**Consultation Response from KC,
Highways Development Management**

2025/90809 Grange Nurseries, North View Road, East Bierley, BD4 6NS

Demolition of existing extensions and porch, erection of extensions and sun lounge to rear

Date Responded: 06/08/2025

DETAIL
PROPOSED SITE PLAN WITH ENTRANCE
SLOPING DRIVE DOWN TO HARDSTANDING
AND PARKING BAYS WITH A CHARGING POINT

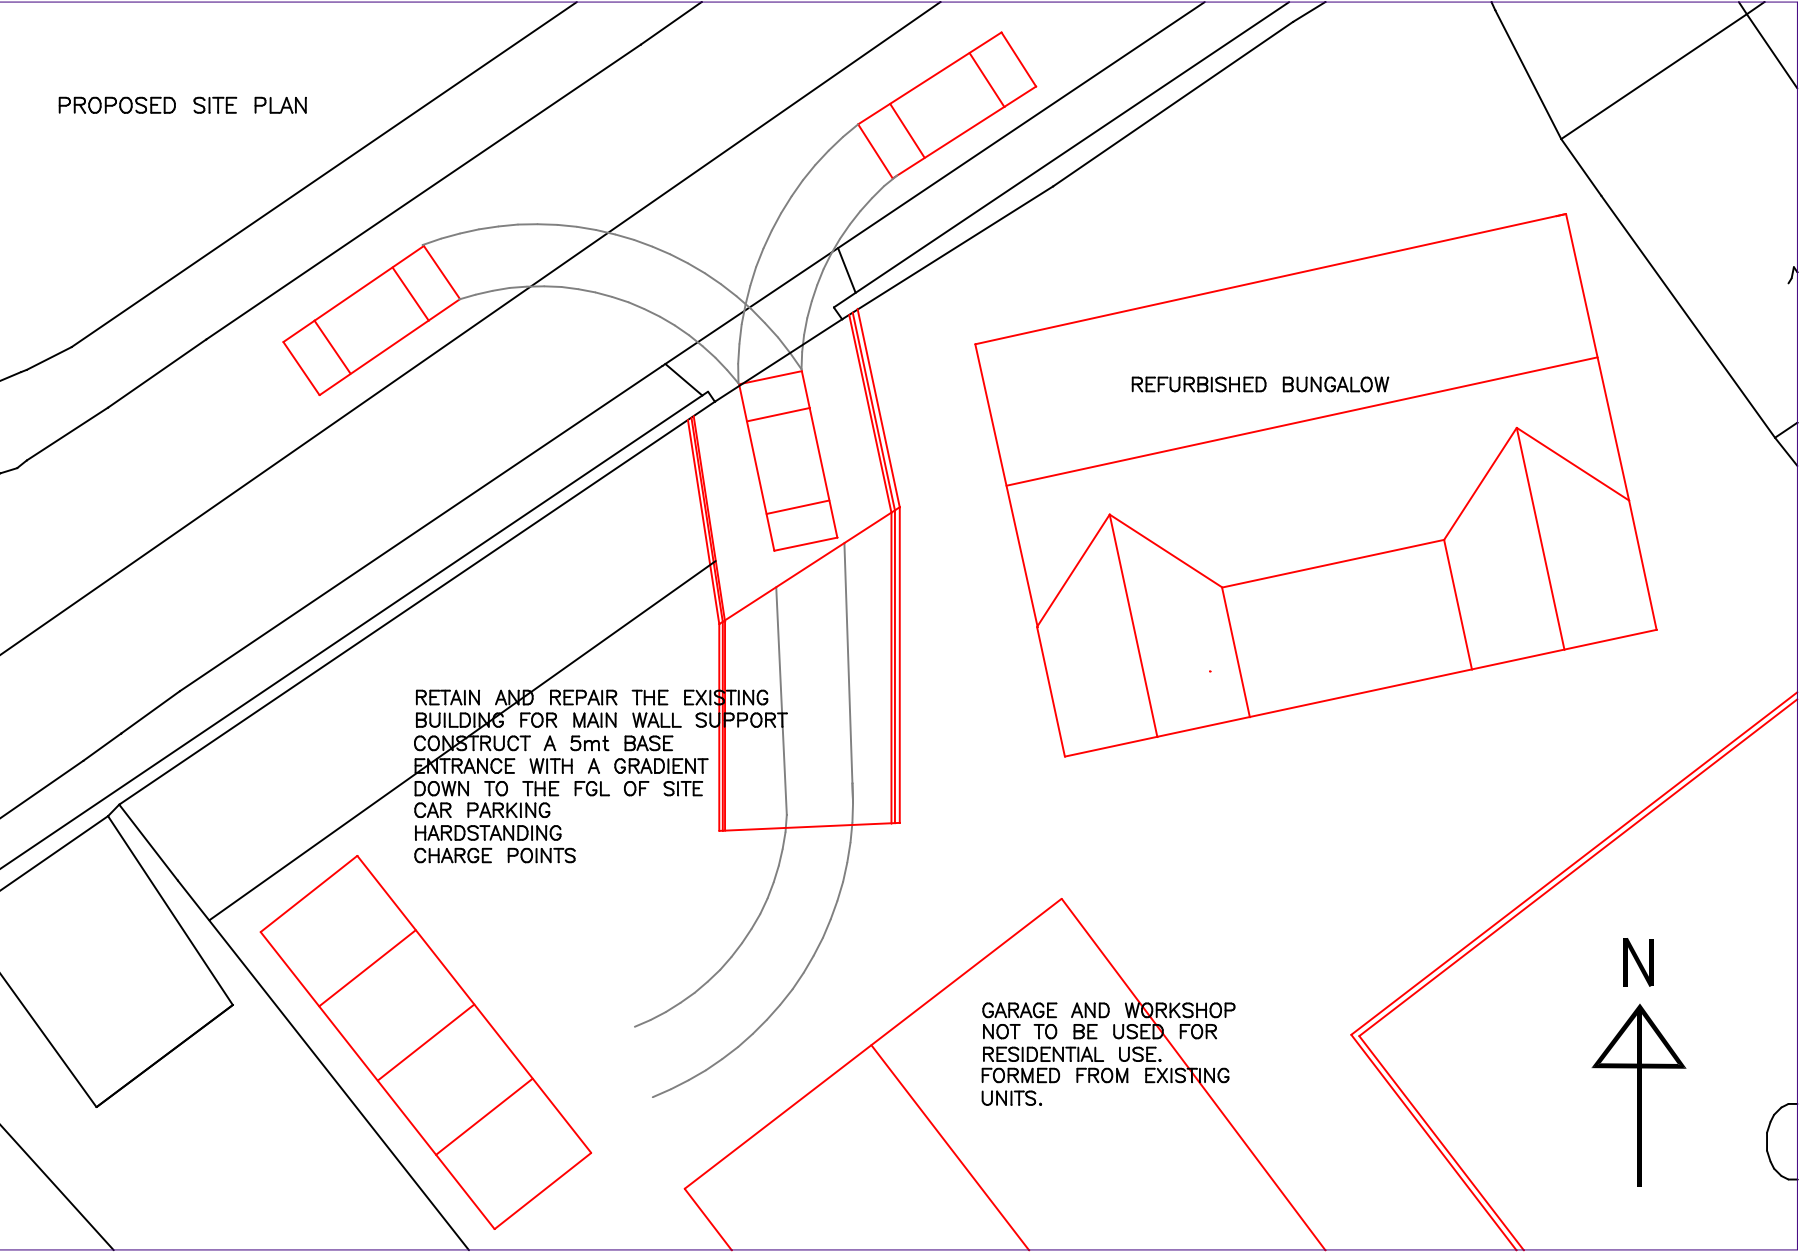
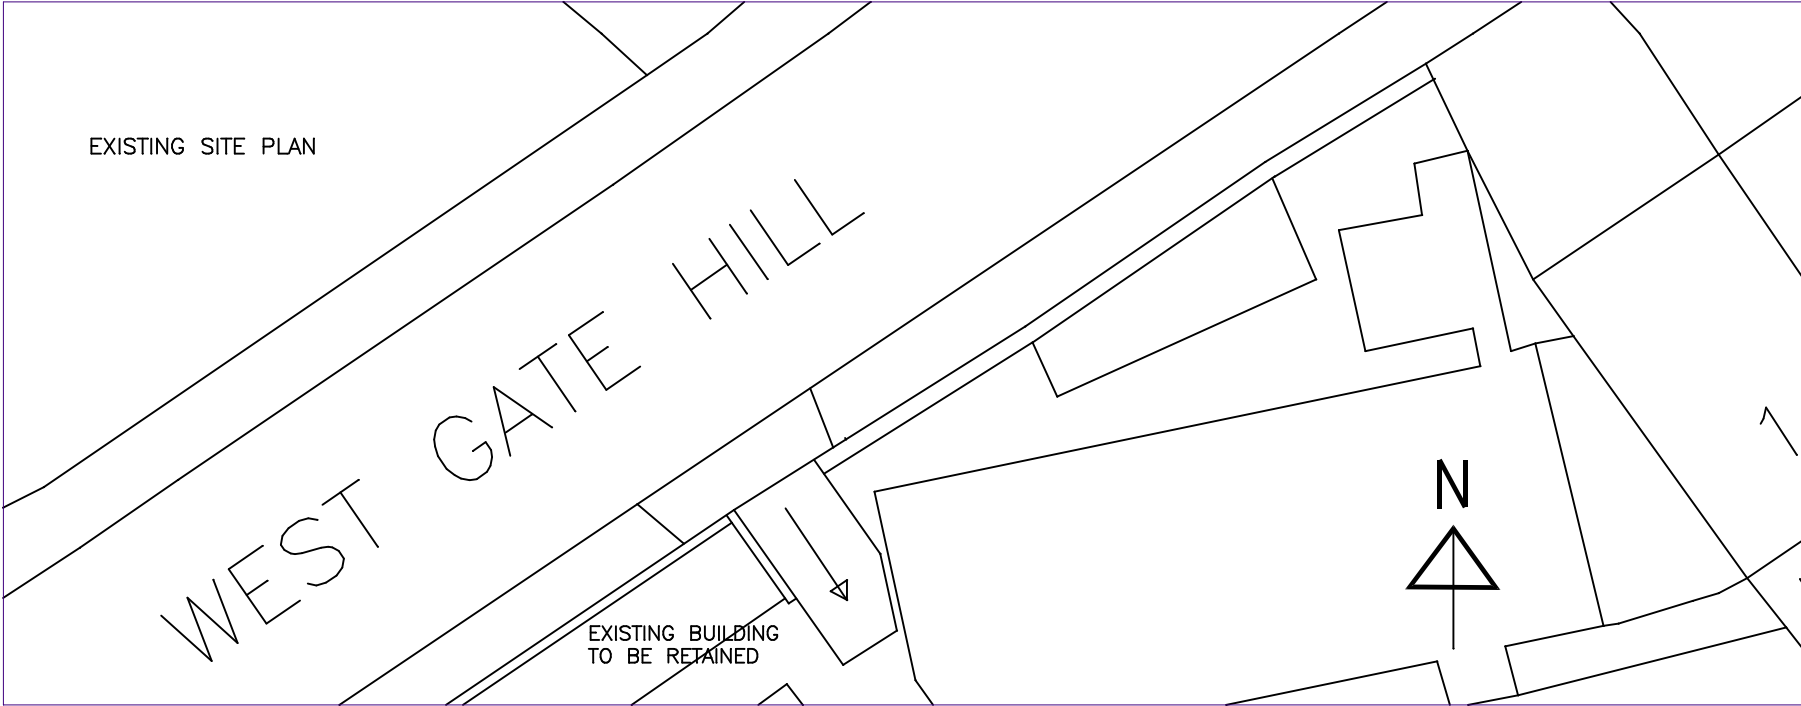
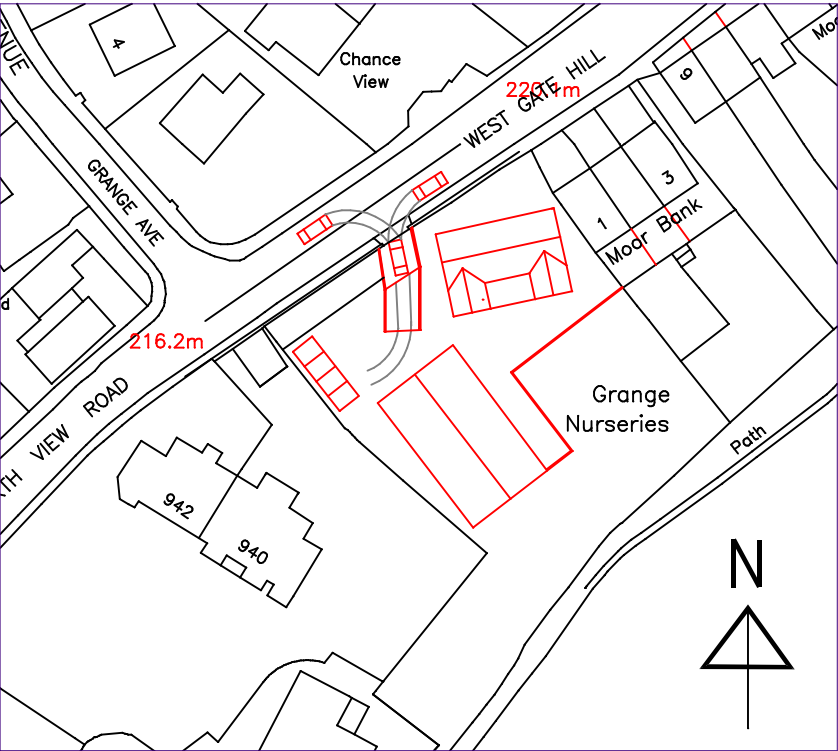
- A revised layout showing the required visibility splays should be provided to ensure that the minimum visibility can be provided for vehicles leaving the site.
- A revised layout showing the details of the access ramp should be provided to ensure that the retaining wall/ramp meets the requirements of the Kirklees Highway Structures Team

The width of the proposed access is shown as being approximately 4m wide which is acceptable.

Manual for Streets states that for a 30mph speed limit sight lines of 2.4m x 43m should be achievable and demonstrated on a suitable plan. Any shortfall of this requirements should be in accordance with 85%ile wet weather speed readings (if below 30 mph).

There is an existing bus stop and shelter on North View Road that may need relocating if it obstructs visibility.

The ramp into the lower internal area appears to be too steep and short to allow for vehicle access to the internal area. The ramp should ideally be at a gradient of no more than 1 in 10.

A revised plan should be provided showing the levels and gradient of the ramp.

To ensure the new access and ramp does not compromise the stability of the adjacent retaining wall of the adopted highway no development shall take place until details of the siting, design, structural calculations and material to be used in the construction of retaining walls/ structures near or abutting highway have been approved in writing by the Highways Structures.
